**Consultation Response from Mike Hibbert,  
KC Waste Strategy( Refuse & Recycling)**

**2023/91405 Part of former St Luke's Hospital site, Blackmoorfoot Road, Crosland Moor,  
Huddersfield, HD4 5RA**

**Erection of foodstore (class E) with associated access, parking, servicing area and  
landscaping**

**Date Responded:6/06/2023.**

date **August 2022**  
status **Planning**  
scale **1:500 @ A3**  
drawn **NG** checked **BM**  
job no. **2783** dwg no. **P401** rev.

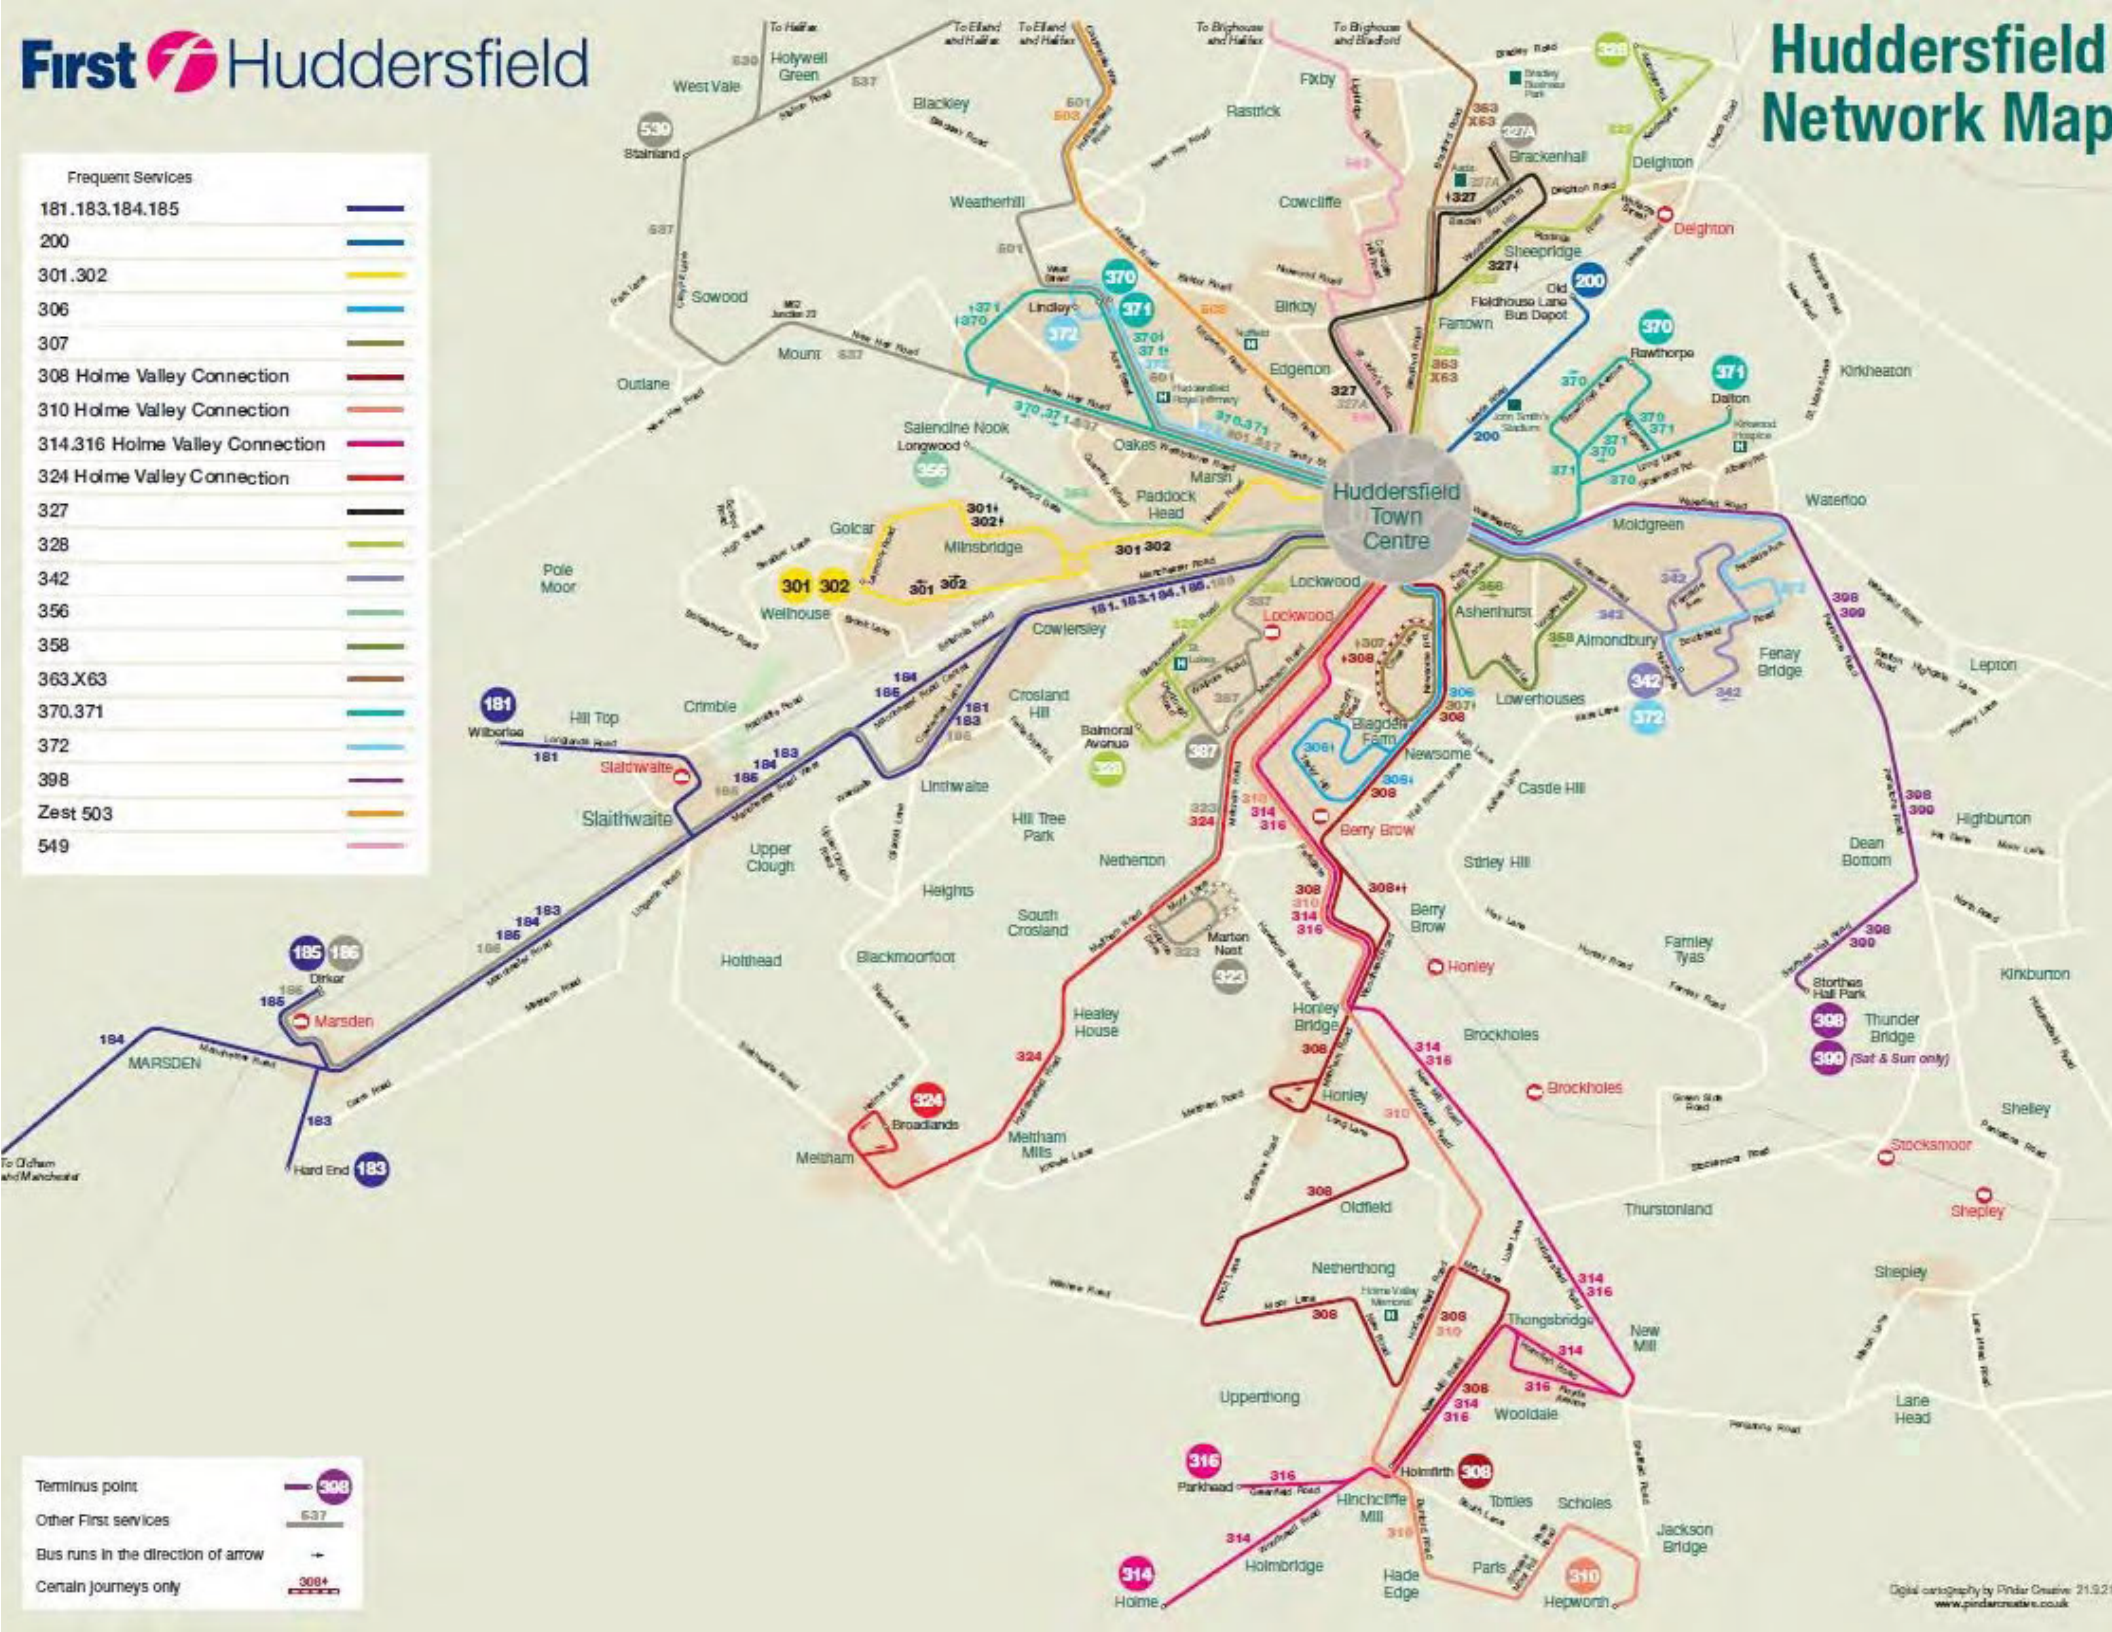
The application relates to erection of a new Lidl food store (Use Class E) with associated car parking and landscaping. The following comments refer to Blackmoorfoot Road Proposed Site Plan Dwg P401 Rev B dated 14/03/2023.

- It is welcomed that the plan shows a space adjacent to the store entrance annotated as DRS Room to ensure compliance with proposed Deposit and Return Scheme legislation.

- A baler shown on the plan is located near the loading bay at the rear of the store. It is not clear if the DRS collected packaging will be baled on site and managed in the same manner as in-store generated waste. If so, this would entail transporting the waste or receptacles along the welfare corridor prior to storage and dispatch. If waste from DRS is to route via the pedestrian entrance, stored externally in additional containers or will have provision for a separate contractor to collect these materials with specialist waste vehicles this will impact on location of any waste storage compound and highway specification for turning points and therefore should be addressed.
